Our Ref: BE/98/21/NMA

Non material amendment following the grant of BE/135/18/PL for the adjustment of bell mouth access to the unit 3 plot and associated planting. The new planted bund to north of unit 3 plot within village buffer to provide screening of unit 3 building.

Land At Salt Box West Of Shripney Road Bognor Regis PO22 9NW

UNIT 3 ACCESS
EXISTING AND PROPOSED
1744-P06

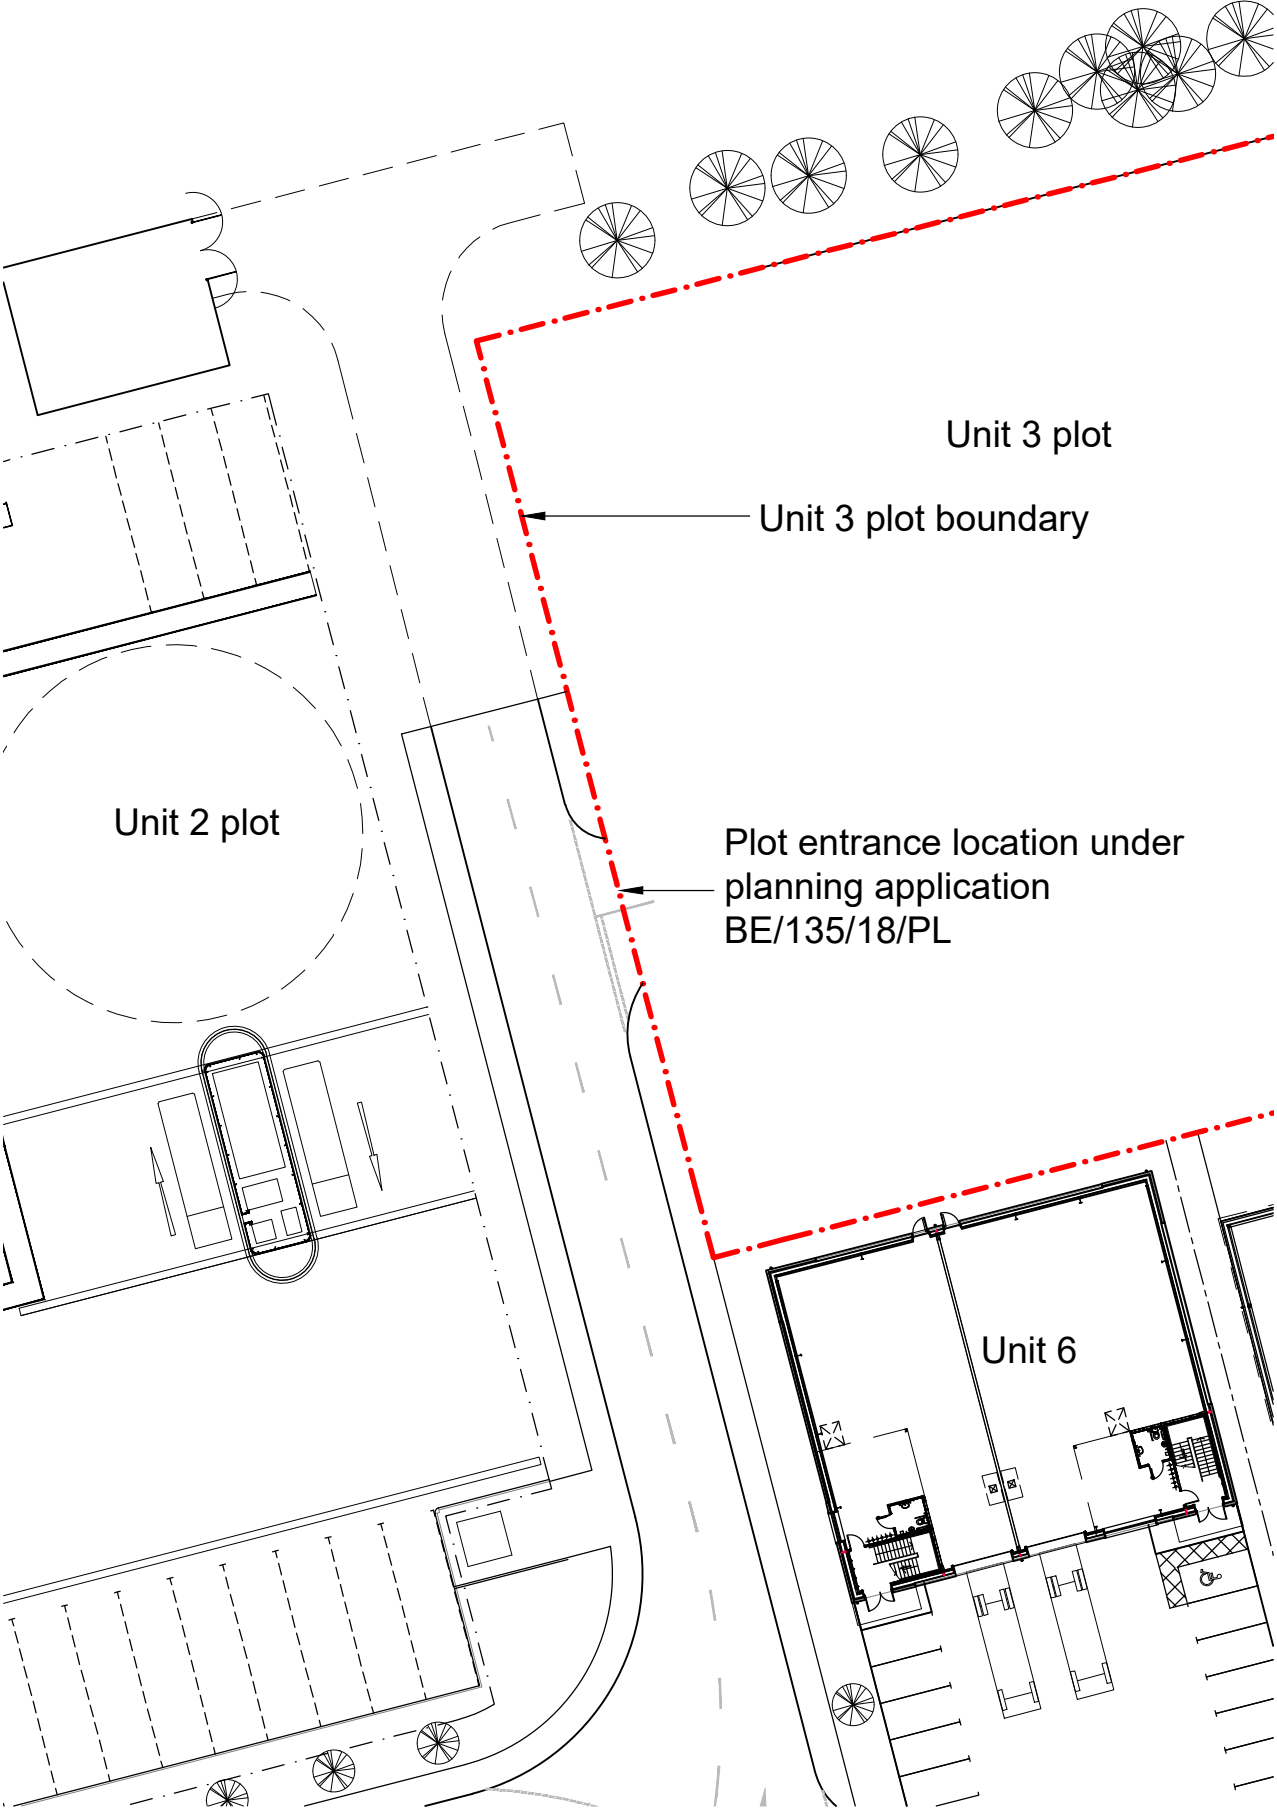
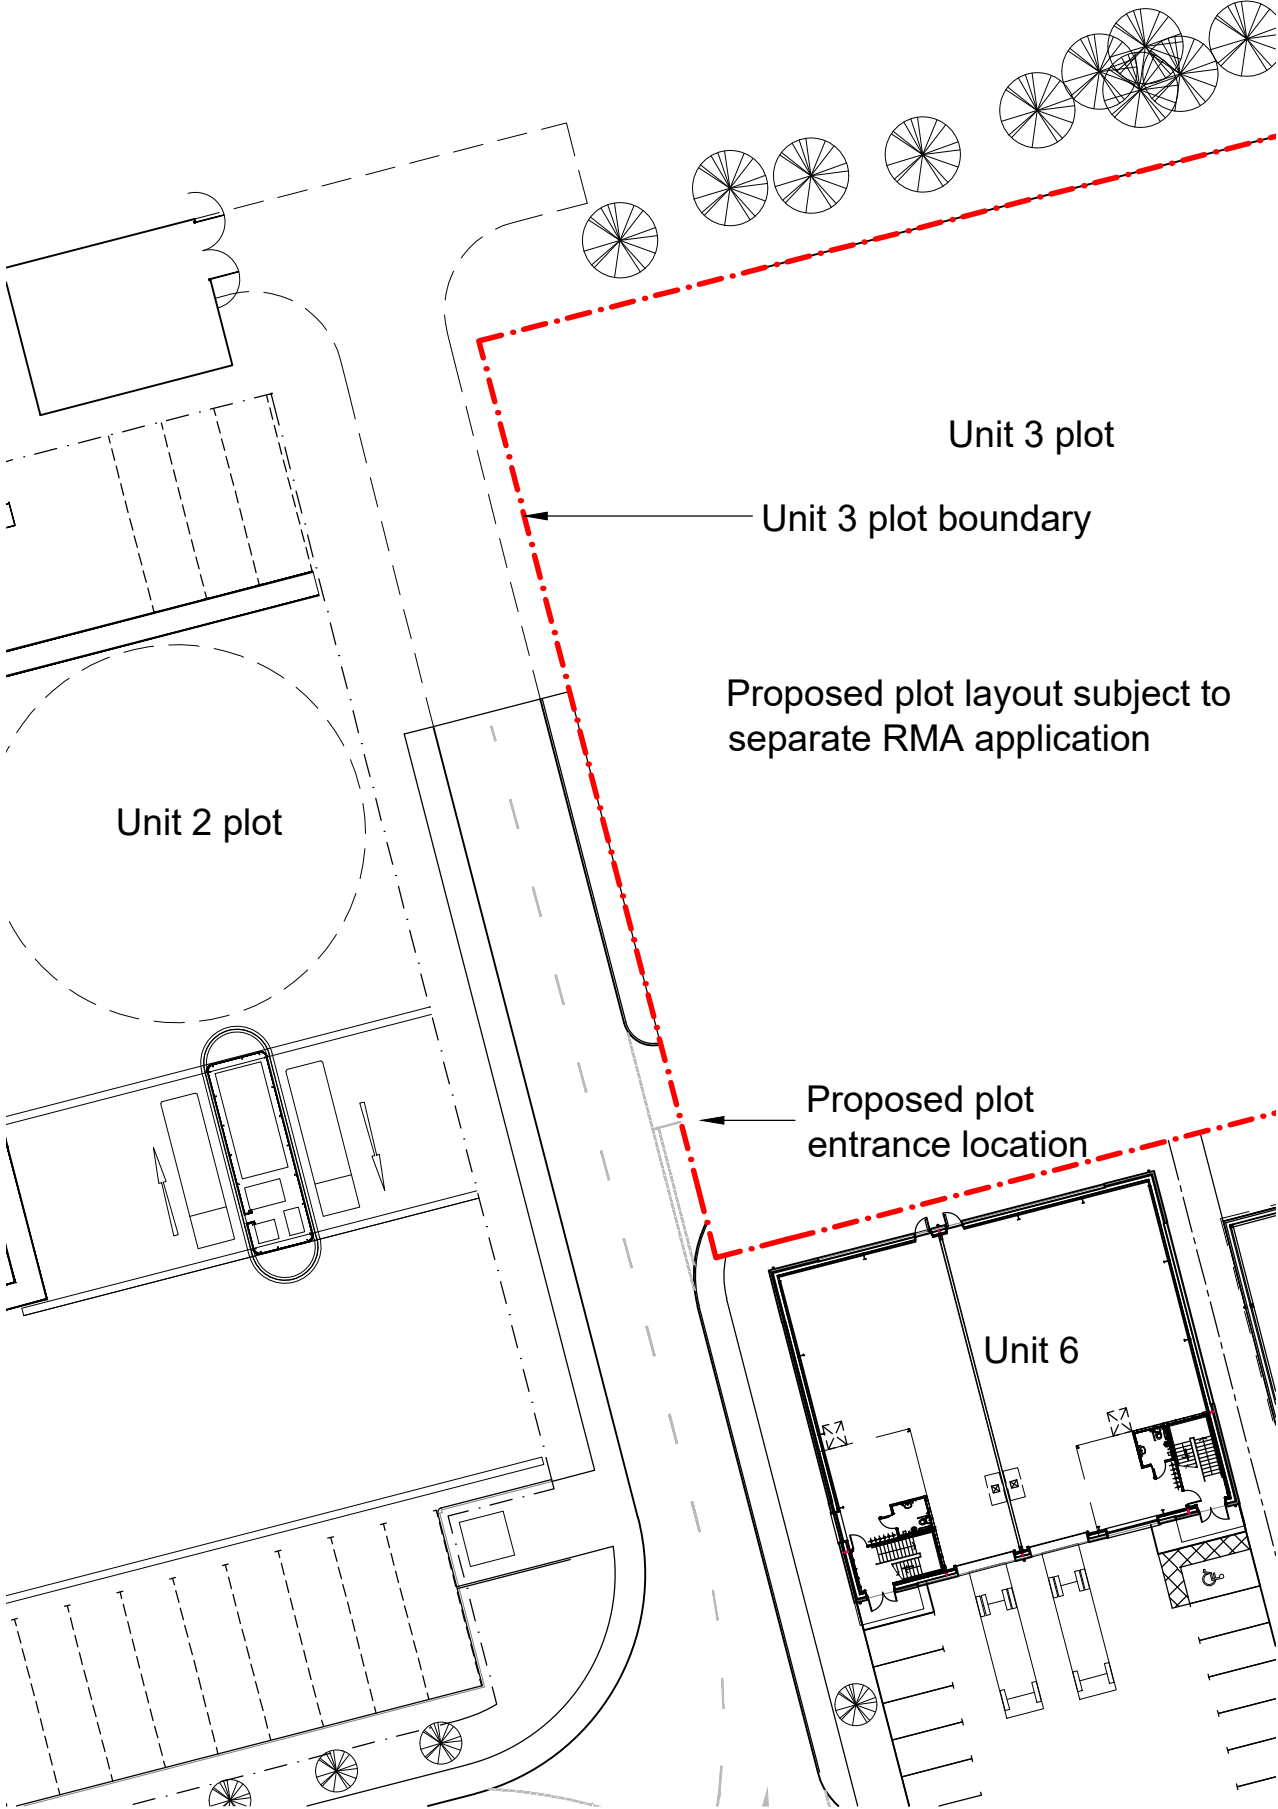
Notwithstanding this, the proposed alteration to the bell mouth access to Unit 3 would constitute a Minor Non-Material Amendment to planning permission (BE/135/18/PL) at Salt Box, Shripney Road, Bersted as it constitutes an amendment that does not have a material impact on neighbouring residents and would not warrant re-consultation either of neighbours, council departments or statutory bodies; but a separate Section 96A application would be required to be submitted for approval.
